KITTITAS COUNTY COMMUNITY DEVELOPMENT SERVICES

October 1, 2008

Kittitas County Community Development Services has determined that the DW Farms Short Plat (SP-08-00021) is a complete application and hereby grants *conditional preliminary approval* subject to the following conditions:

**DW FARMS SHORT PLAT**  
LOCATED IN SECTION 32, TOWNSHIP 18 NORTH, RANGE 20 EAST, W.M.  
KITTITAS COUNTY, WASHINGTON  
SP-

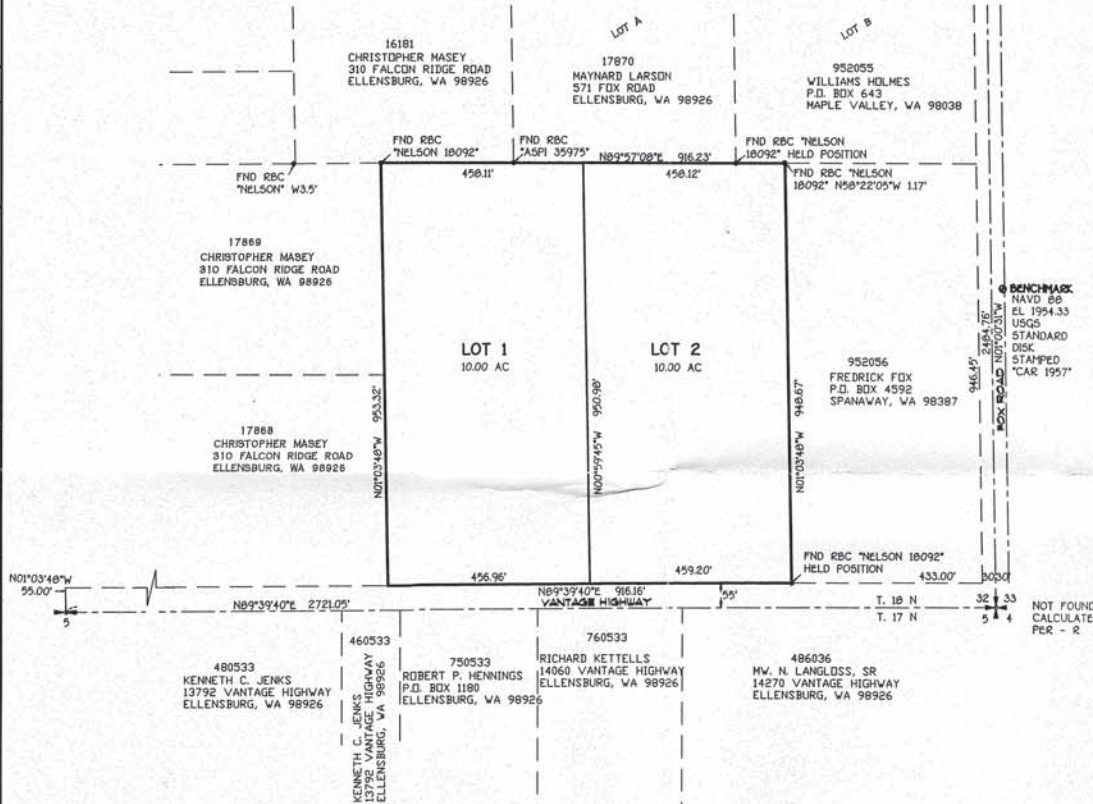
10. Legal Description: The legal description shall be corrected to read "...as recorded January 7, 2005, in Book **30** of Surveys, Page 222..."
11. Easement 'R': The west boundary of the property is encumbered by Easement 'R' as recorded in Book 28 Page 231 and deeded to neighboring properties. The easement shall be shown on the final plat.

13. Existing Access: The existing access shall be shown on Sheet 1 of 2.
14. Joint-Use Driveway: A joint-use access shall serve no more than two tax parcels. See Kittitas County Road Standards, 9/6/05 edition.
